**Response Matrix**

Cornerstone House of Refuge Apostolic Church  
2375 St Laurent, Ottawa

February 28, 2023

drawing no. 20037_SP1 rev. no. 0

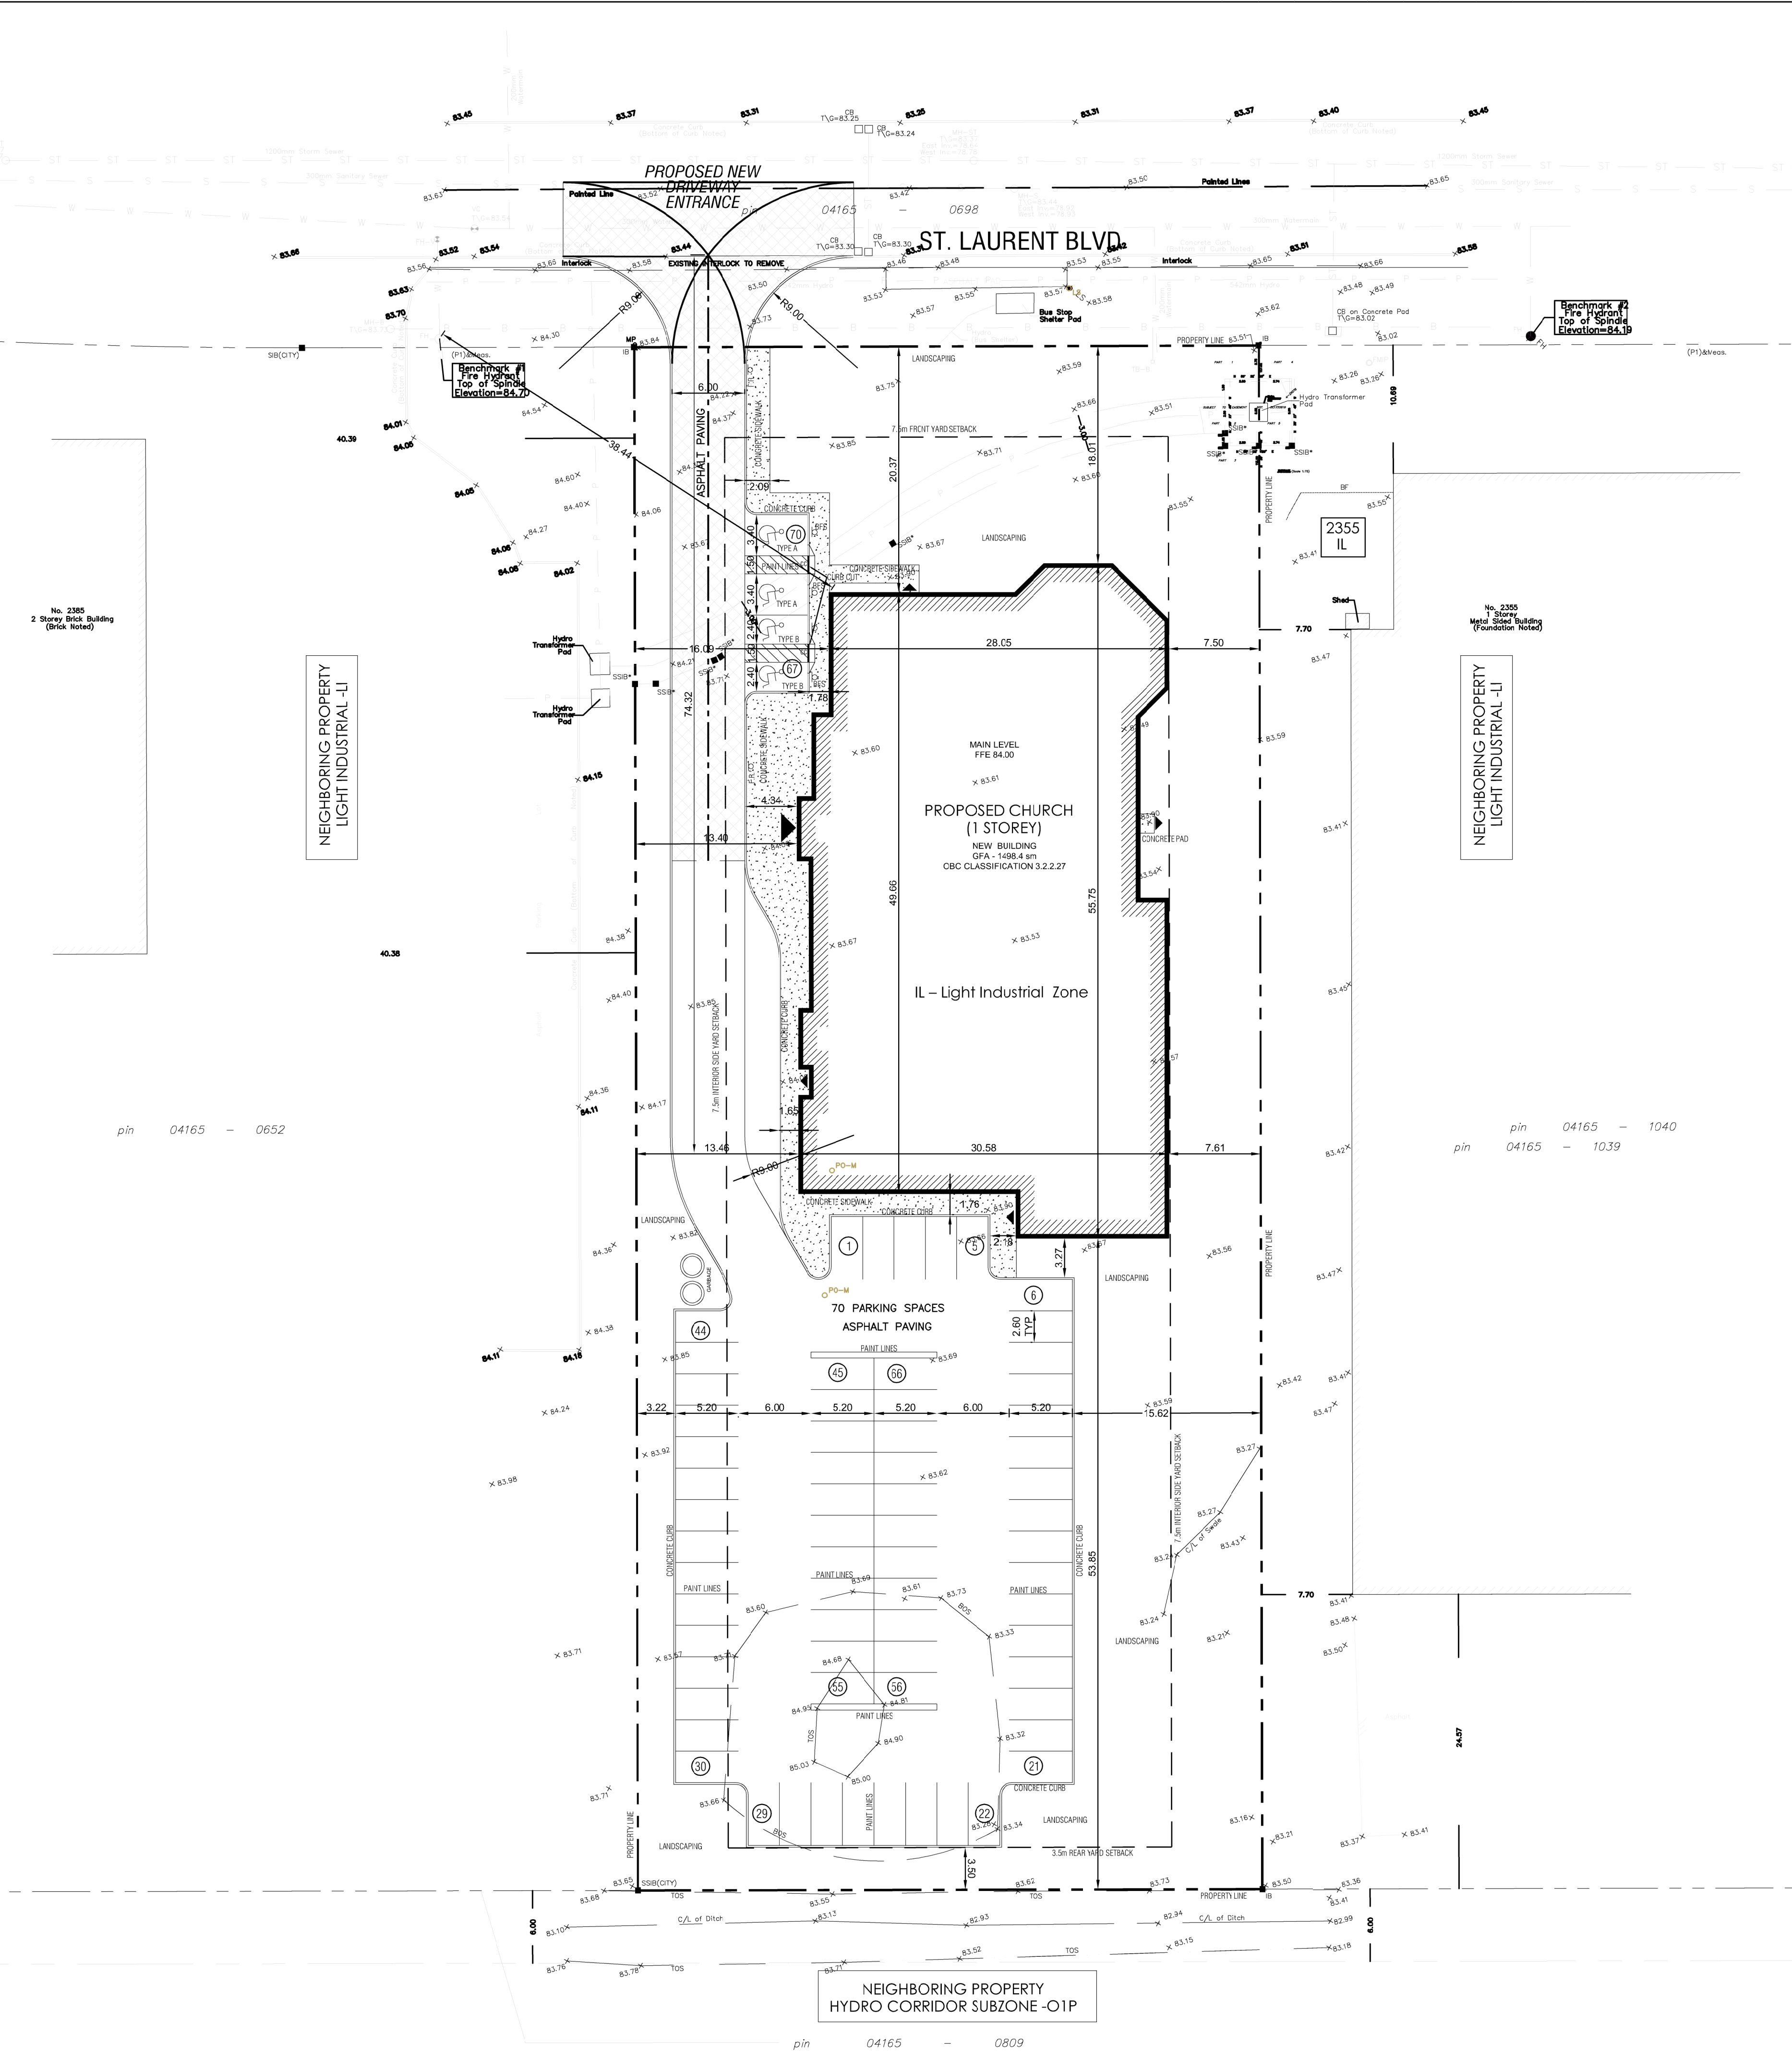
<u>Comment</u>	<u>Response</u>
<b>Siobhan Kelly - Development Review - South Branch - Planning Comments - City of Ottawa</b>	
<p>2. Section 203 (2)(g)(ii) states that a Place of Worship is permit subject to it having a maximum gross floor area of 1000 m<sup>2</sup>. The proposed building is identified as being 1,498.4 sq. m. Are you planning on submitting a Zoning By-law Amendment or Minor Variance application to have the building conform to the zoning standards?</p> <p>Partially address. As proposed, the parking lot does not comply with Section 107 of the Zoning By-law. The minimum required aisle width is 6.7 metres. Reducing the size of the landscape buffer adjacent to the parking lot will provide additional space for the drive aisles. As the property is zoned Light Industrial (IL), the Zoning By-law does not prescribe a min width for the landscape buffer between the perimeter of the parking lot and lot line.</p> <p>Another option is to reduce the size of some of the parking spaces to meet the required drive aisle width. Section 106 states that up to 50% of the parking spaces may be reduced in size to 4.6 m long and 2.4 m wide, provided that the spaces are: visibly identified for a compact car, not a visitor parking space; and, not abutting or near a wall, column, or other surface.</p>	<p>Parking aisles have been adjusted to 6.7m wide throughout the site plan drawing and compact vehicle parking has been denoted on the SP1 drawing.</p>

<p>3. Please ensure that the garbage enclosure complies with Section 110, which require it to be 3.0 m from a lot line and screened from view. If it is an in-ground refuse container, the screening requirement can be achieved with soft landscaping.</p>	<p>Dimension has been shown on SP1 drawing and landscaping added to the landscape plans.</p>

cad file 20037_SP3
 date plotted 12/13/2022 plot scale 1:1

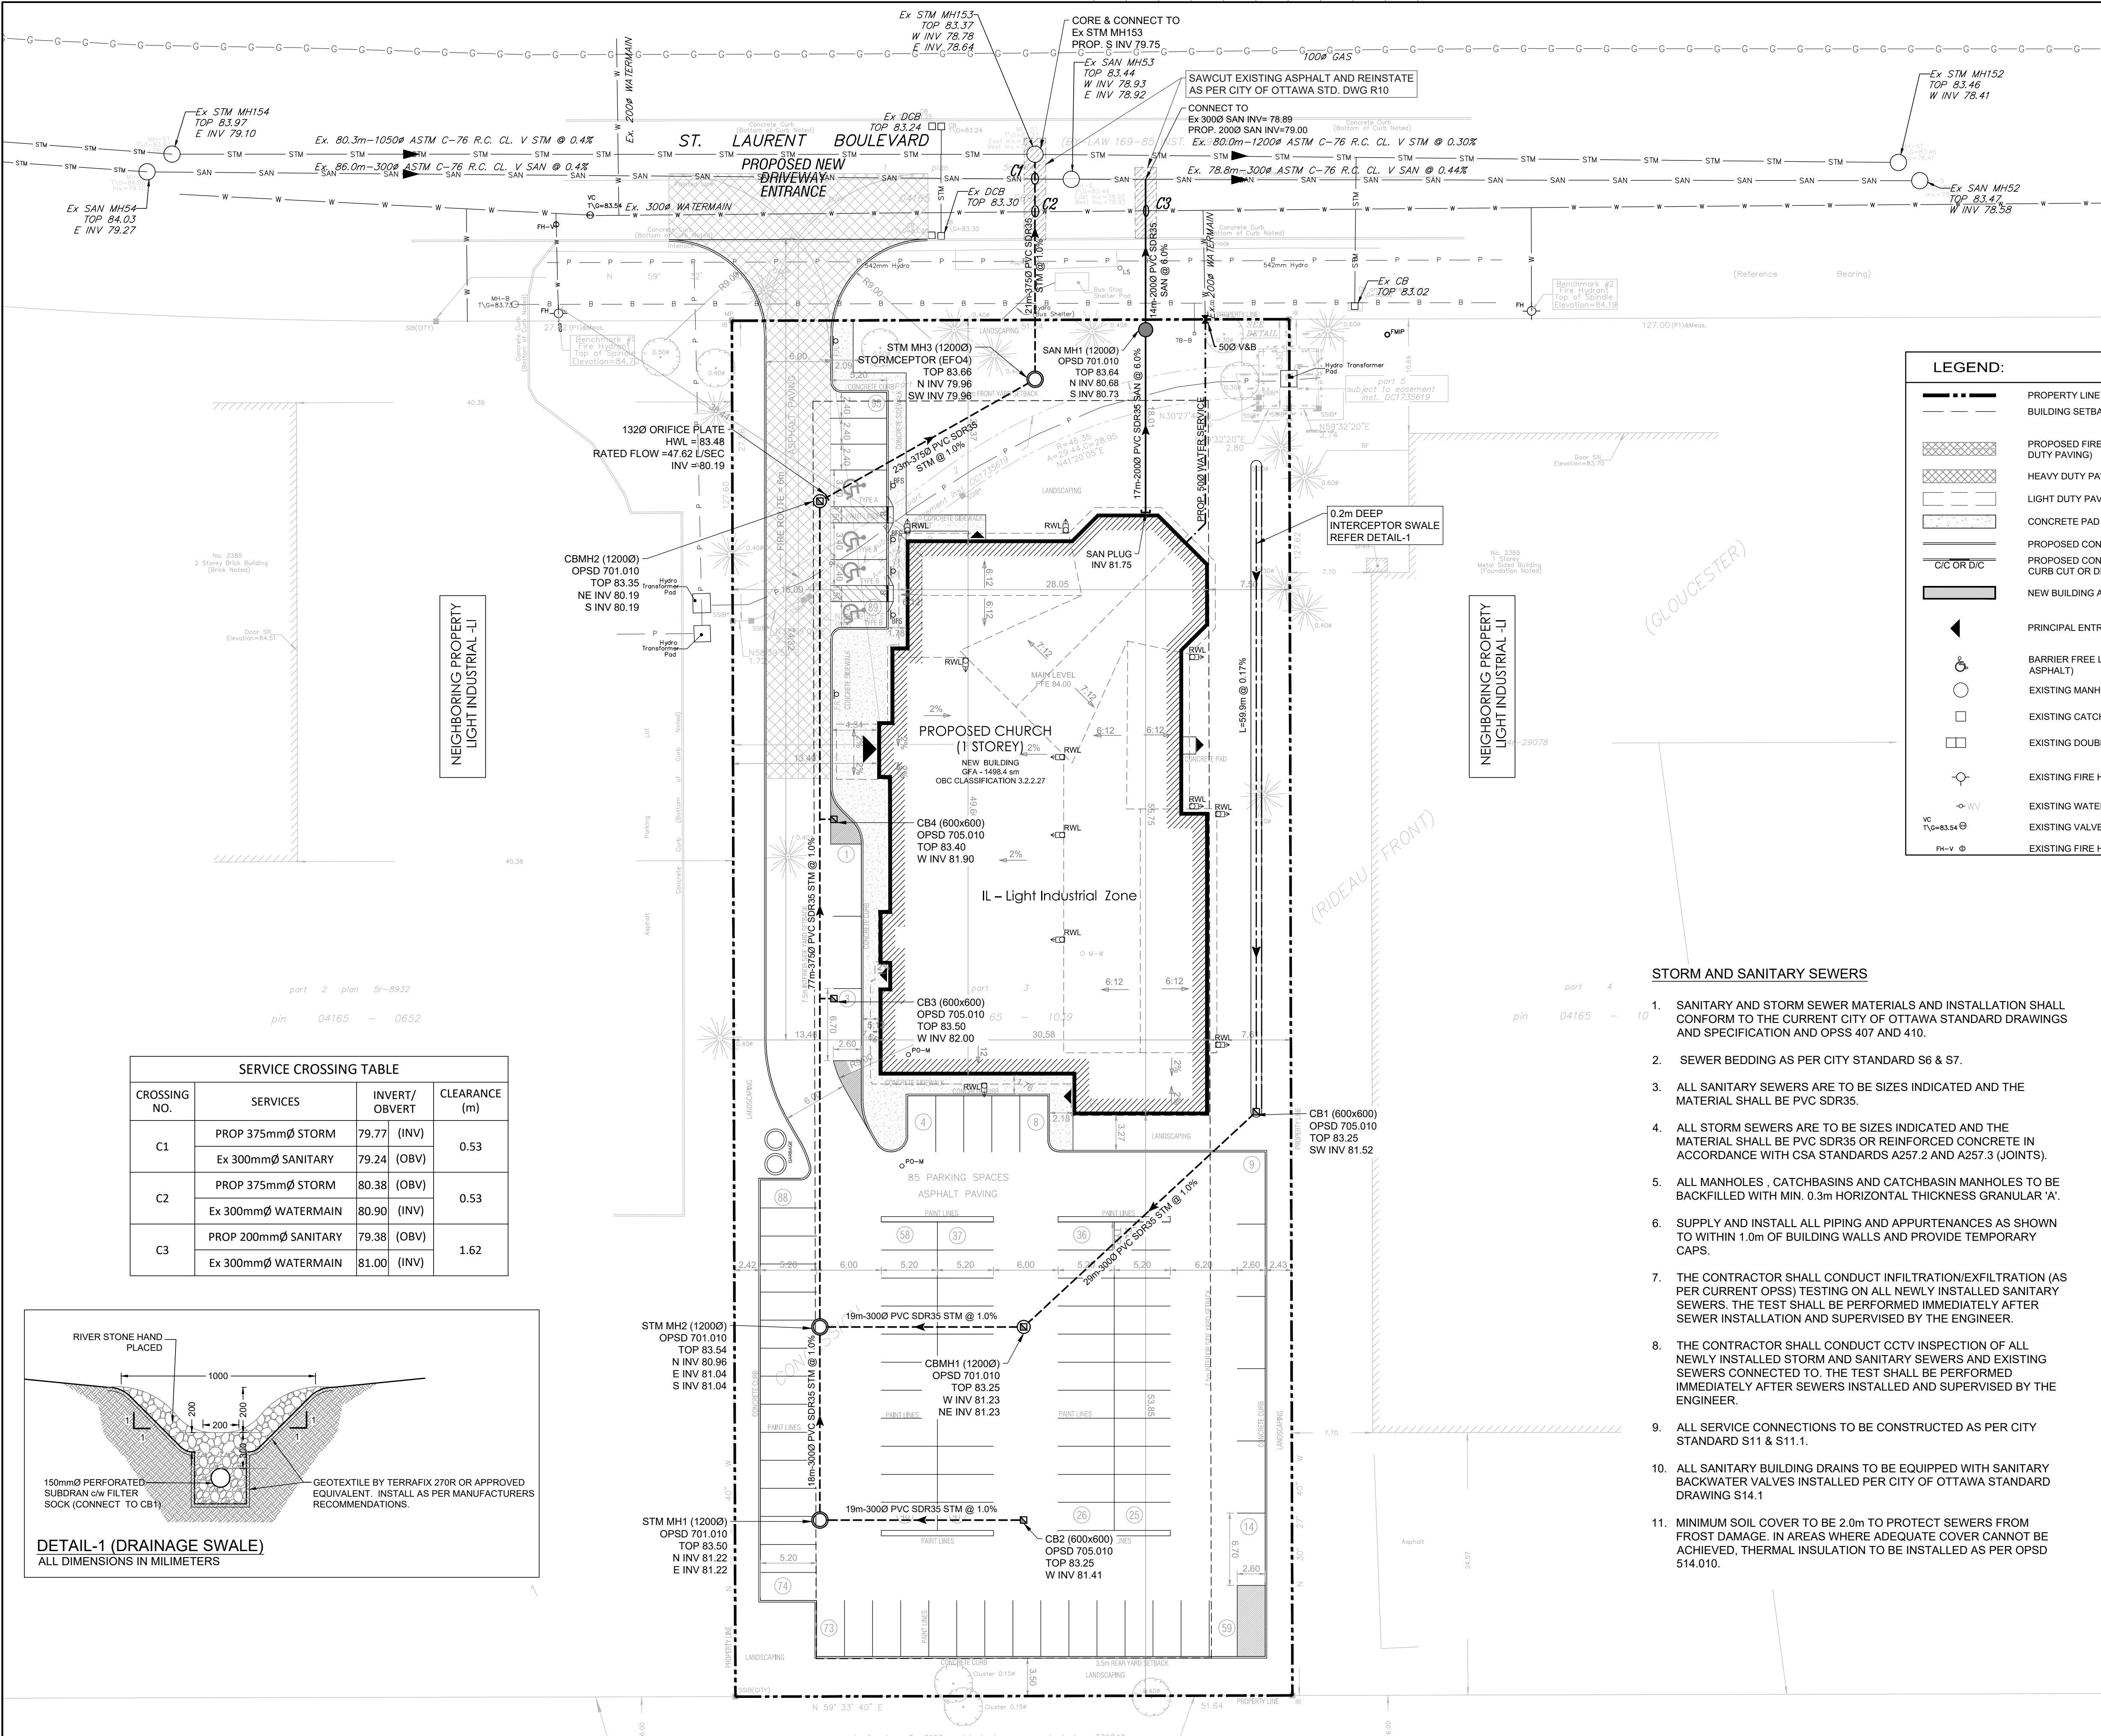
<p>B5 Please ensure the proper benching is provided in all MH's as per SDG 6.2.12.</p>	<p>Note added on Drawing SP3.</p>
<p>C. Geotechnical Investigation, prepared by Pinchin Ltd., Project #314869, dated September 30, 2022.</p> <p>C6. Please provide a final geotechnical report which has reviewed the final servicing, grading plan and foundation design loads.</p> <p>Outstanding Please update the geotechnical investigation report to clarify its review of the test civil plans upon the final submission.</p>	<p>Geotechnical Investigation has been updated and the report references the site grading and foundation design as requested.</p> <p>See report attached.</p>
<p>D. Servicing and Storm Water Management Report, prepared by Reinders + Law LTD, dated December 7, 2022.</p> <p>D4 Please provide a ponding plan clearly denoting the 5-year, 100 year and 100 year + 20% climate change stress test elevations including emergency overland flow routes in the case of a blocked CB.</p> <p>Outstanding. See A7 comment.</p>	<p>Ponding plan for required return periods are shown on Grading drawing.</p>
